**Consultation Response from KC,
Highways Development Management****2023/92576 land adj, 1, Long Moor Lane, Shelley, Huddersfield, HD8 8LY****Demolition of outbuildings and erection of detached dwelling with detached garage/store****Date Responded: 13-11-2023.****Responding Officer: Mark Berry****Responding Ref: 12-47-16.**

BLOCK PLAN - 1:200

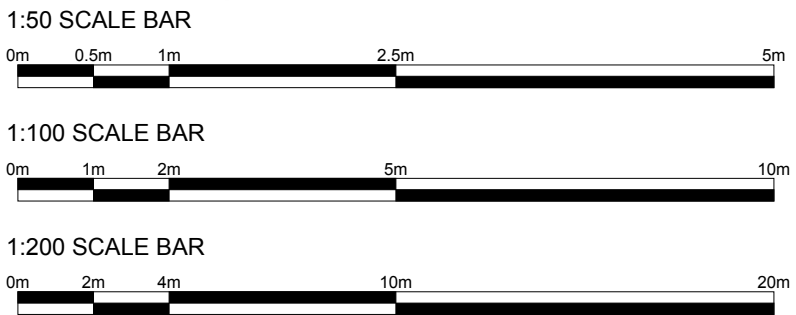
1, Sight lines of 2.4 x site frontage should be shown from the proposed site entrance onto Brook House Lane. To be cleared of all obstructions to visibility exceeding 1 m in height.

2, A bin collection point should be provided to enable bins to be presented on collection day without either obstructing the highway or proposed driveway.
